CITY OF ALBUQUERQUE

April 20, 2015

RE: **Chick-fil-A**
1600 Gibson Blvd SE
Grading and Drainage Plan
Engineers Stamp Date 3/18/15 (M15D012C)

Date :07/01/15

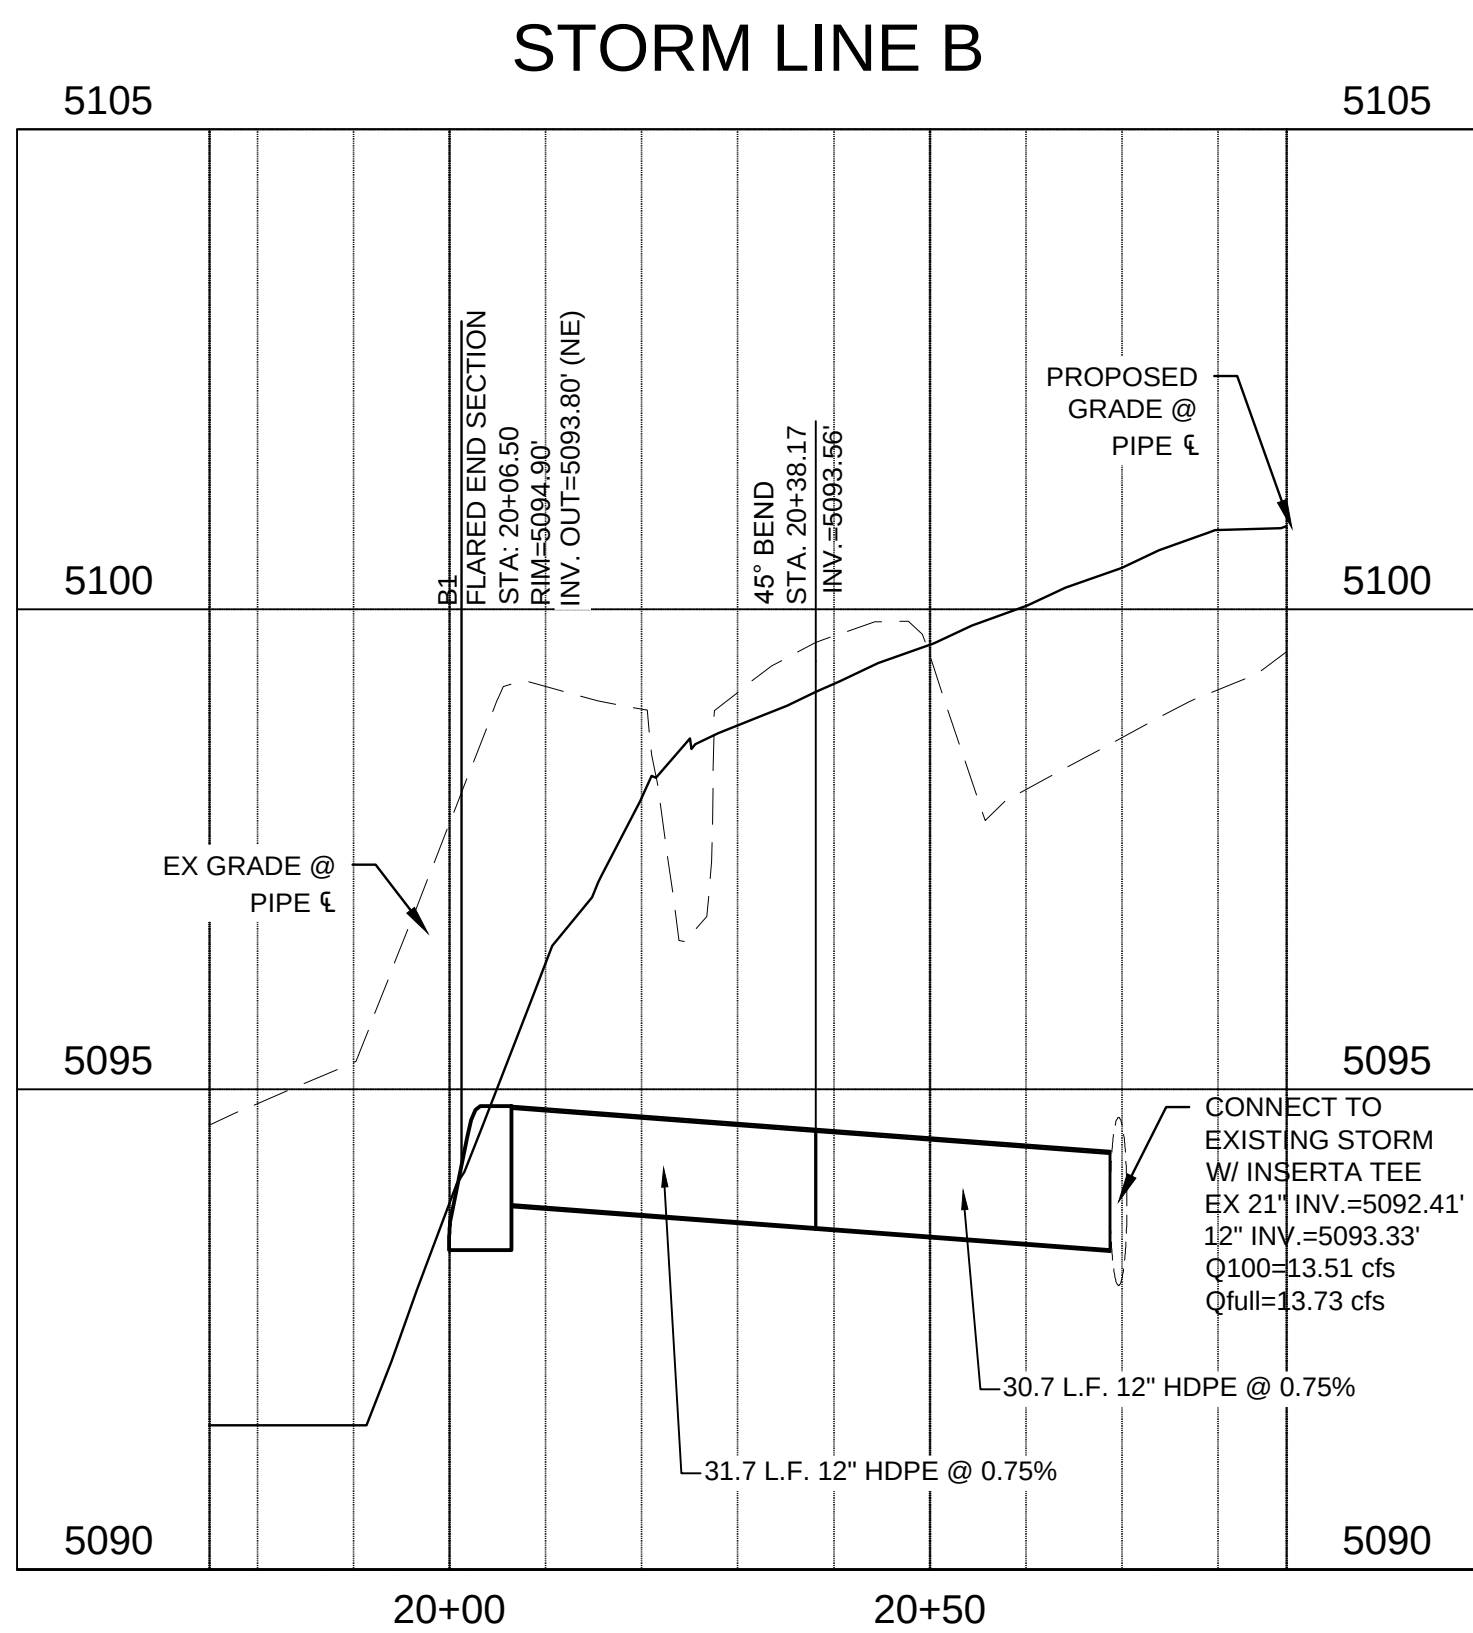
1. Proposed storm drain pipe ties into an existing 21" storm drain.
 - a. Show the existing Storm drain in the profile and section views. Indicate invert elevations of the existing pipe

- d. Provide a connection detail to the 21" storm drain.
2. Verify Pond Bottom Elevation is 92.00 (Sht C3.0). It appears that it needs to be lowered since the invert is at 91.43(Sht C3.3).
